Listed building consent for conversion of & alterations to existing barns to create 3 no. dwellings, erection of car barns & stores, a replacement pump house, demolition of barn, associated landscaping & parking.

Stakers Farm North End Road Yapton

Thank you for your internet comments made on 19th December 2019 which has been recorded as **'an objection'** with the comments as follows:

Drawing Title	Proposed Plans - Barn 3
Scale	1:100 @ A3

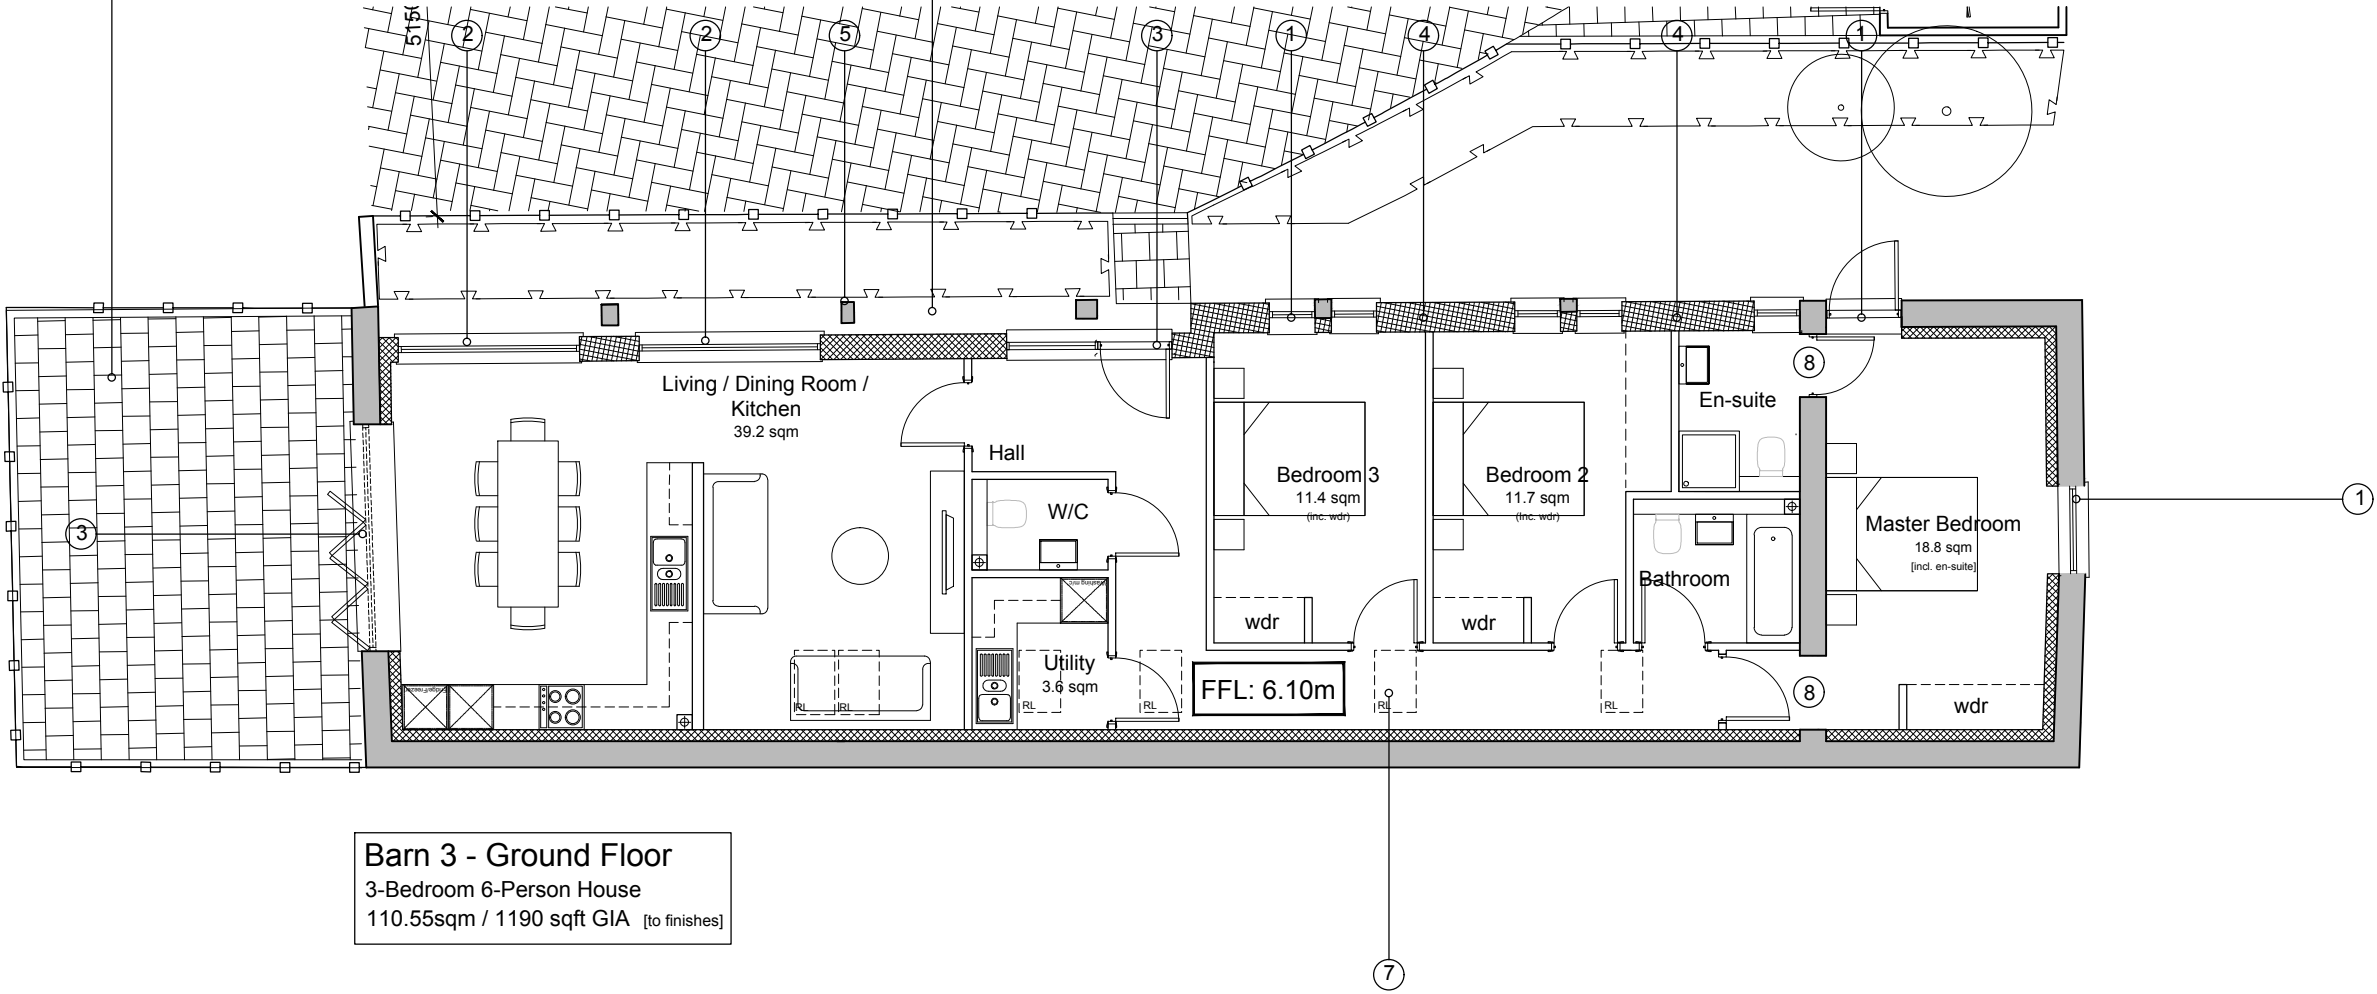
YPC would also state that it regards the proposed amenity space for Barn 3 to be insufficient for a 3 bed house. YPC would also question whether the introduction of a third dwelling in this location actually enhances the site but probably simply causes unnecessary over intensification for a sensitive set of historic farm buildings.
